REF: EN010147 Botley West Solar Farm Representation: Feedback to PVDP Change

Further to my first submission on 5th June, I would like to feedback on the proposed PVDP change proposal.

Title: Illustrative Masterplan
Figure 2.1A
Northern Site Area 1 of 3

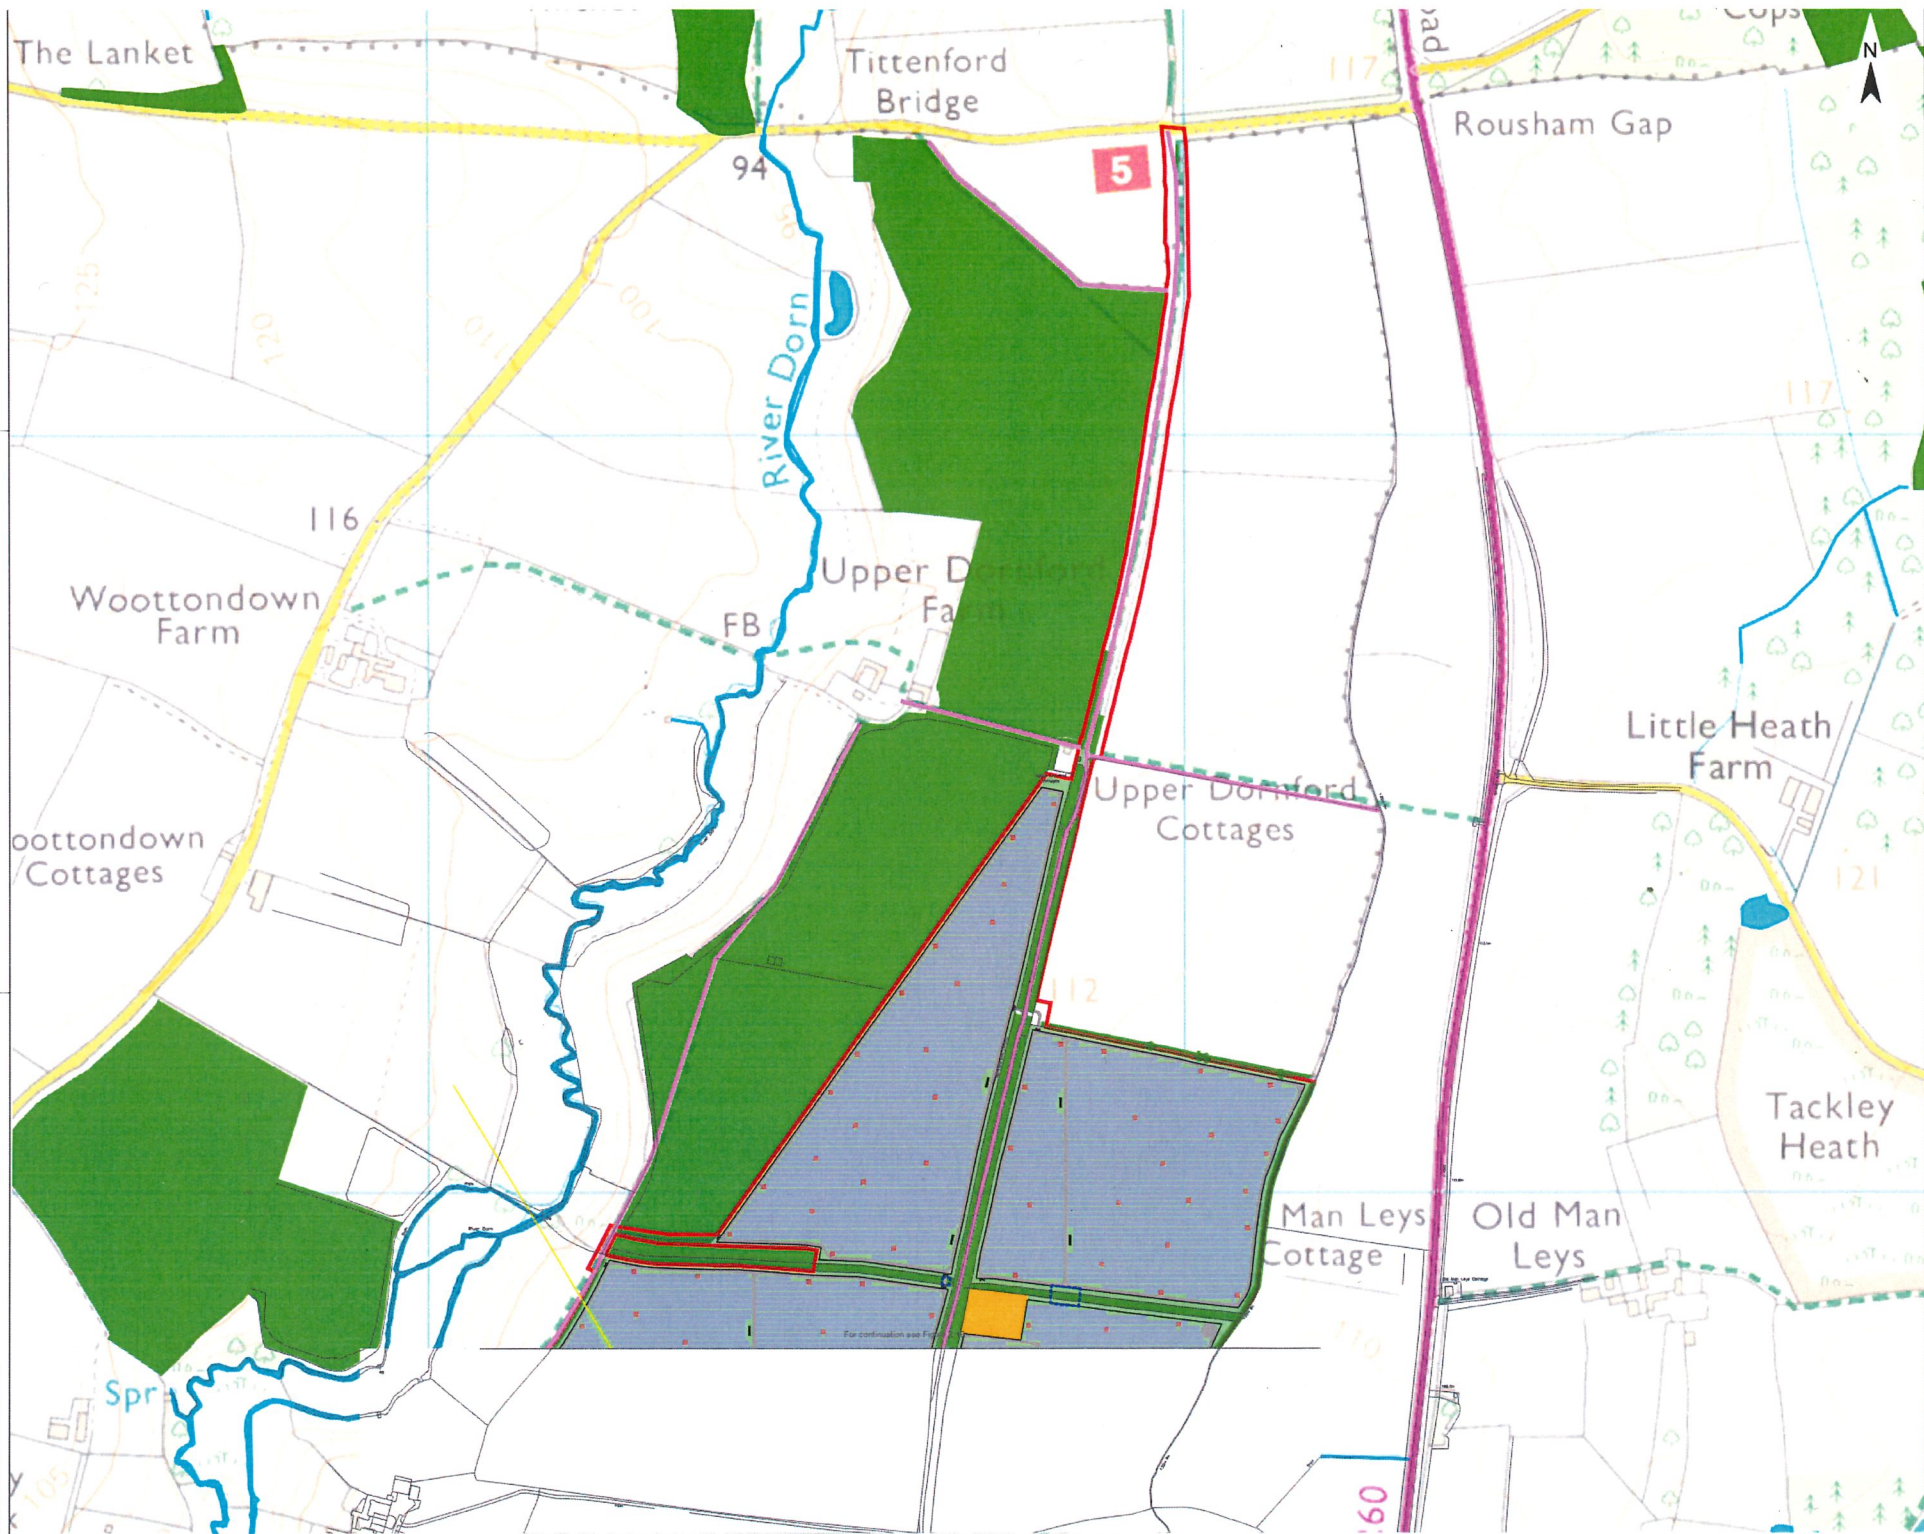
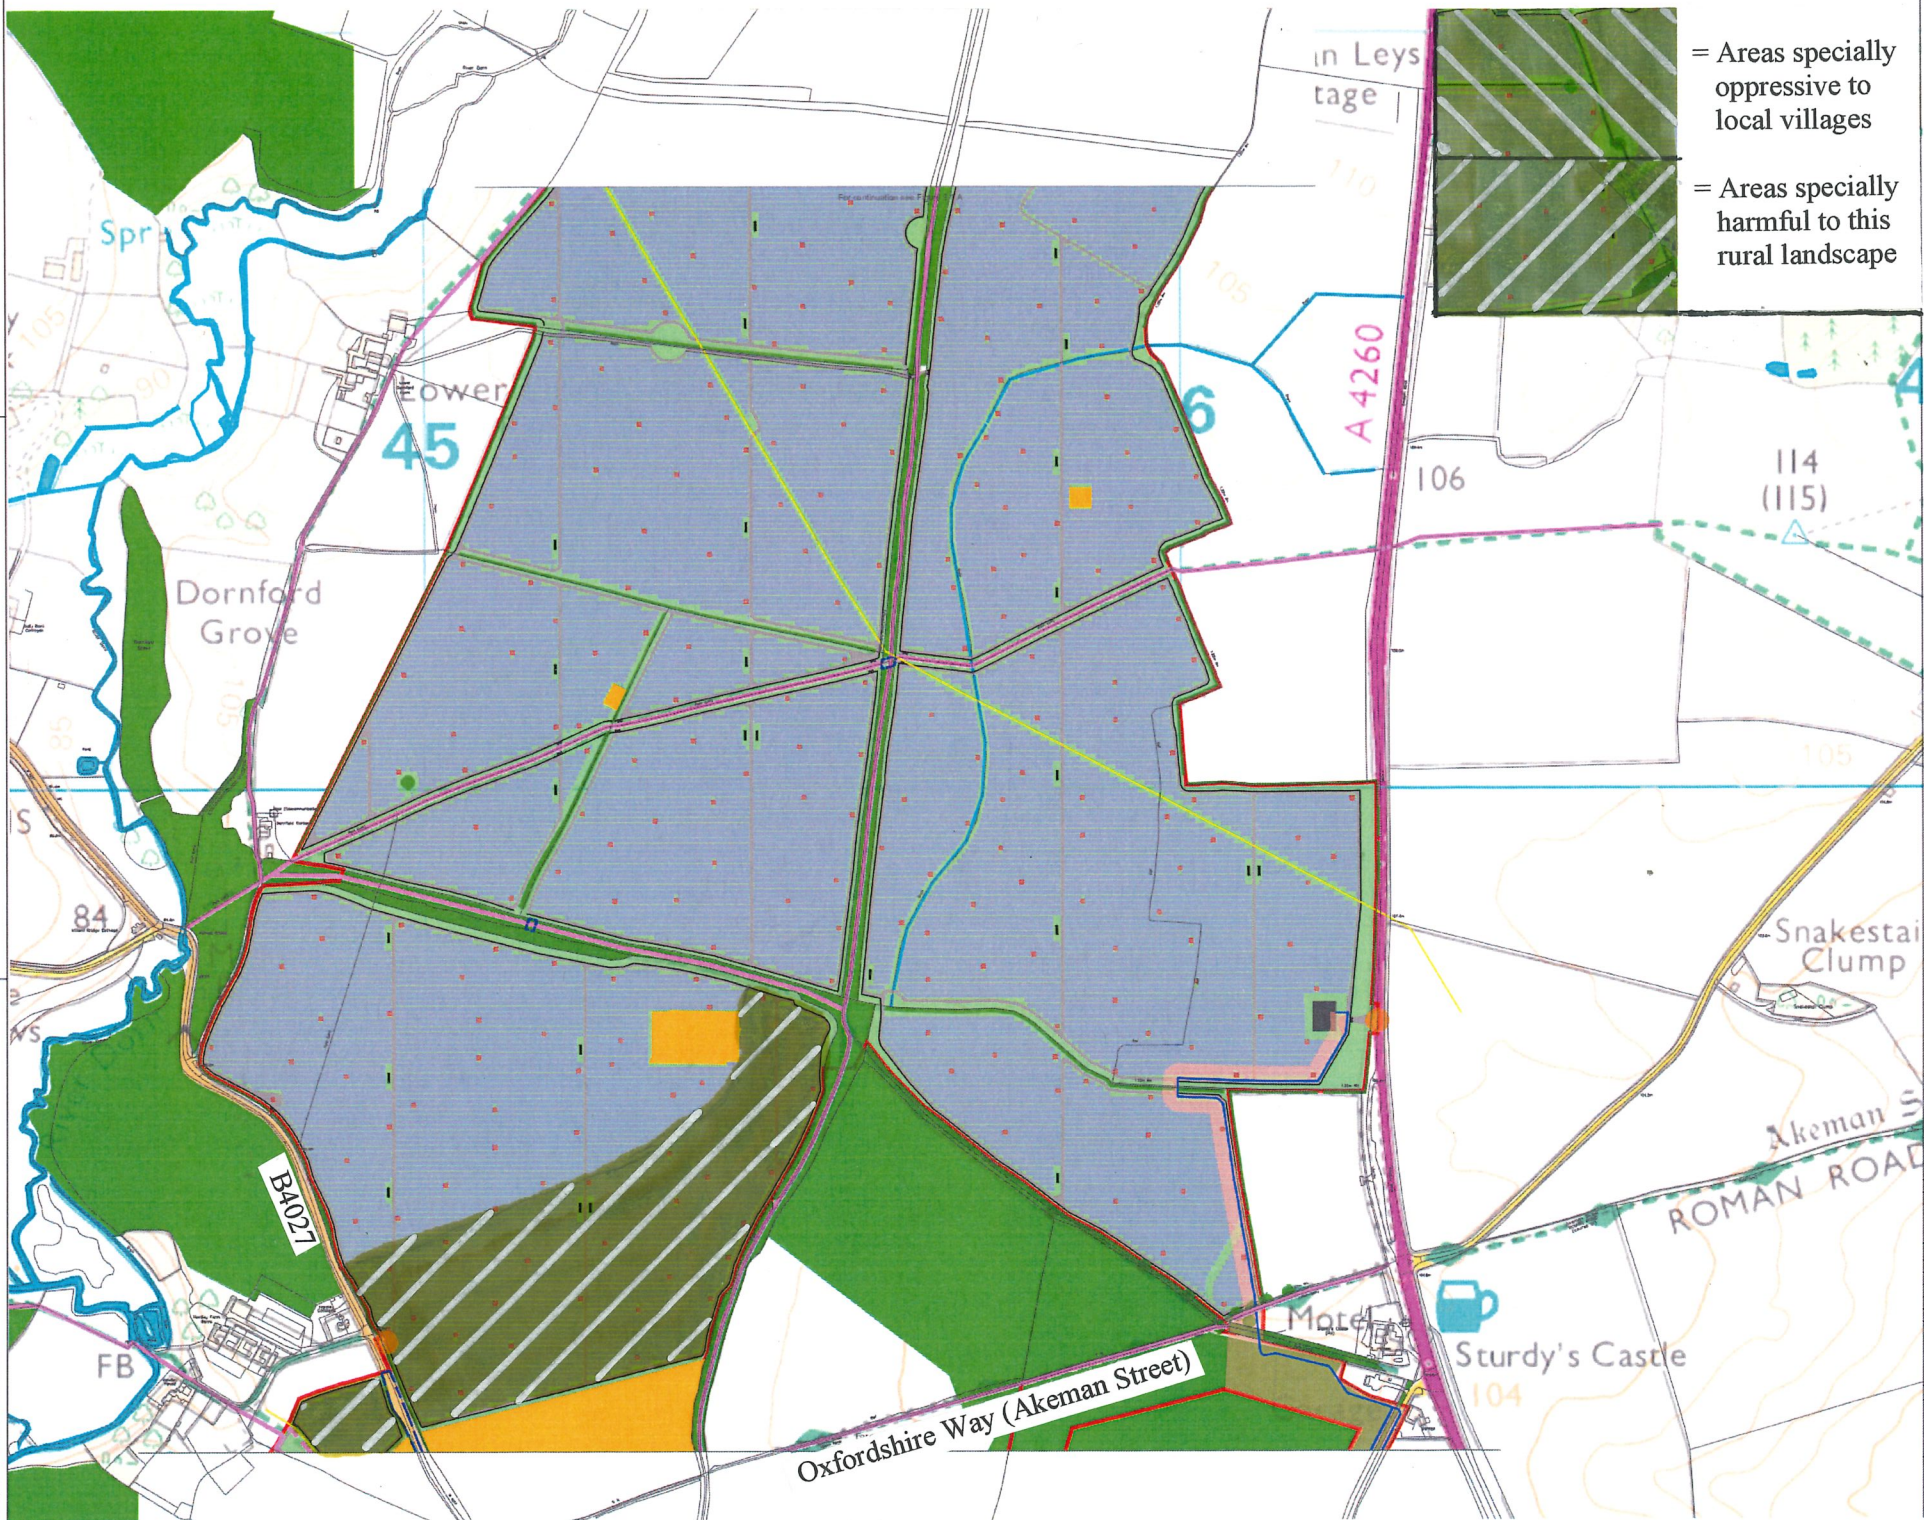
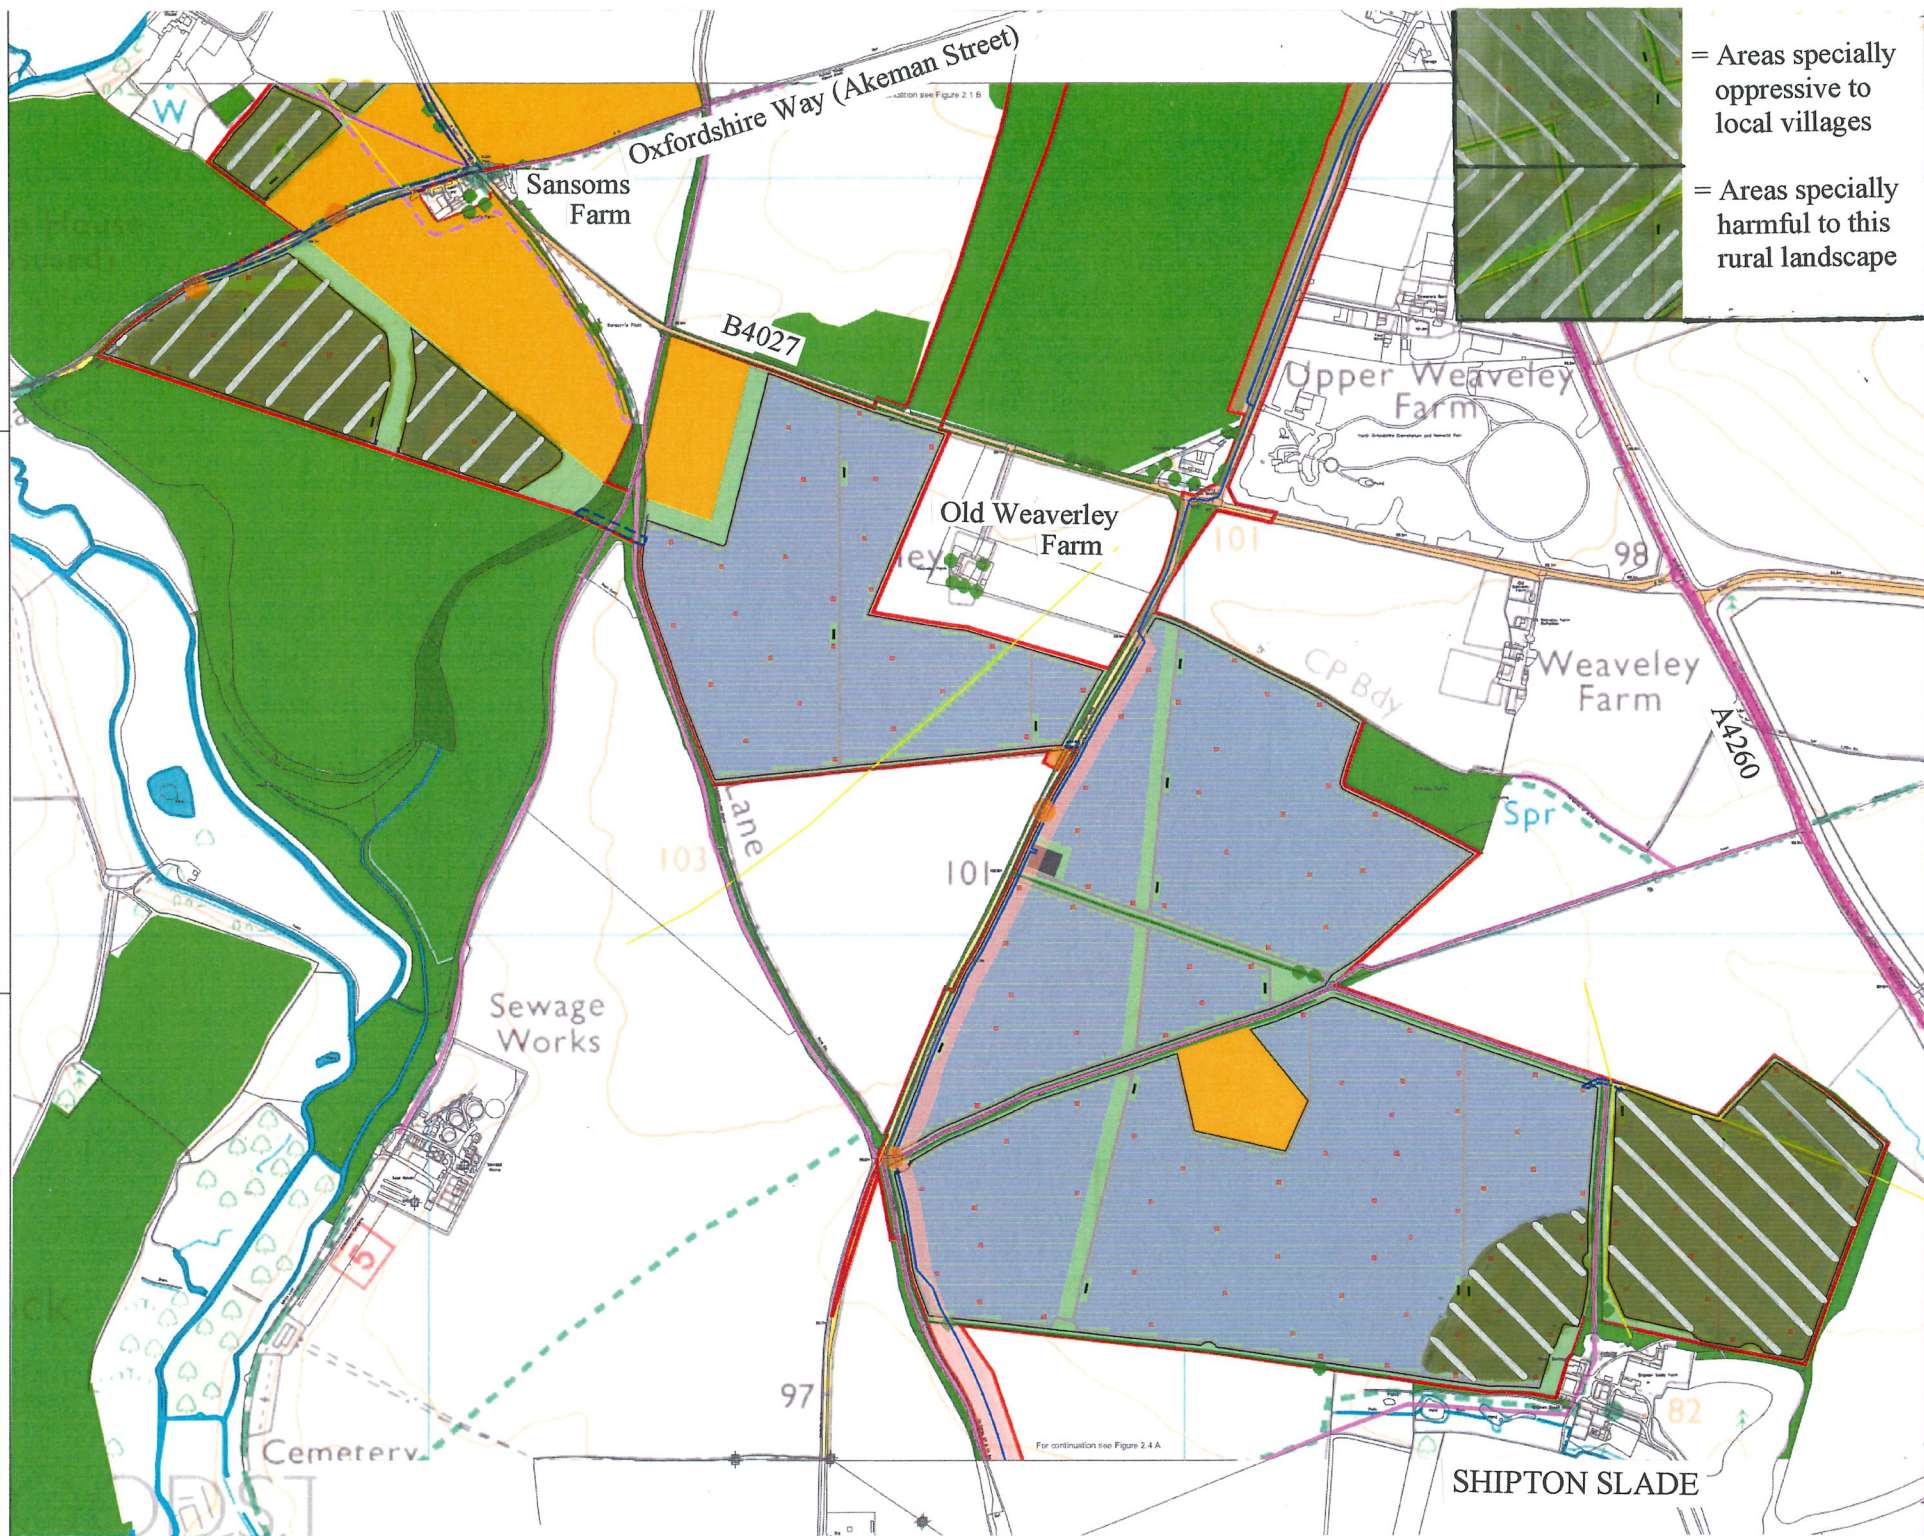
1. My observation having walked the fields with reference to the proposed changes, is that If PVDP conceded the two fields outlined with the **red outline**, then most of the concerns would be removed, and the current natural environment would be maintained. The main walks of Bladon, and visitors to Churchill's Grave, is down Orchard Field Lane and across two footpaths towards St Martin's Church, the main one being the furthest pathway which runs along the Rowel Brook, and ends up at St Martin's Church. The hedge row is mature and would act as a natural barrier to the solar panels behind. This would provide a 30 – 45 minute walk without observing any solar panels.

My concern is the concentration of walkers from their regular 30 – 60 minute walks to the narrow section of fields now proposed.

In summary, the removal of two more fields marked in the image provided, along with the ICOSMOS recommendation, would see the current Bladon walks unaffected. Investigation is required to ensure that migrating deer/animals from the woods are not affected by the solar farm. Buffer zone protection for the wider villages needs to be in line with that offered to Bladon. A full risk assessment needs to be carried out on the risk of fatal plane crashes within the solar farm. There needs to be full transparency of the funding of PVDP to ensure guarantee of completion if the solar farm is to go ahead.
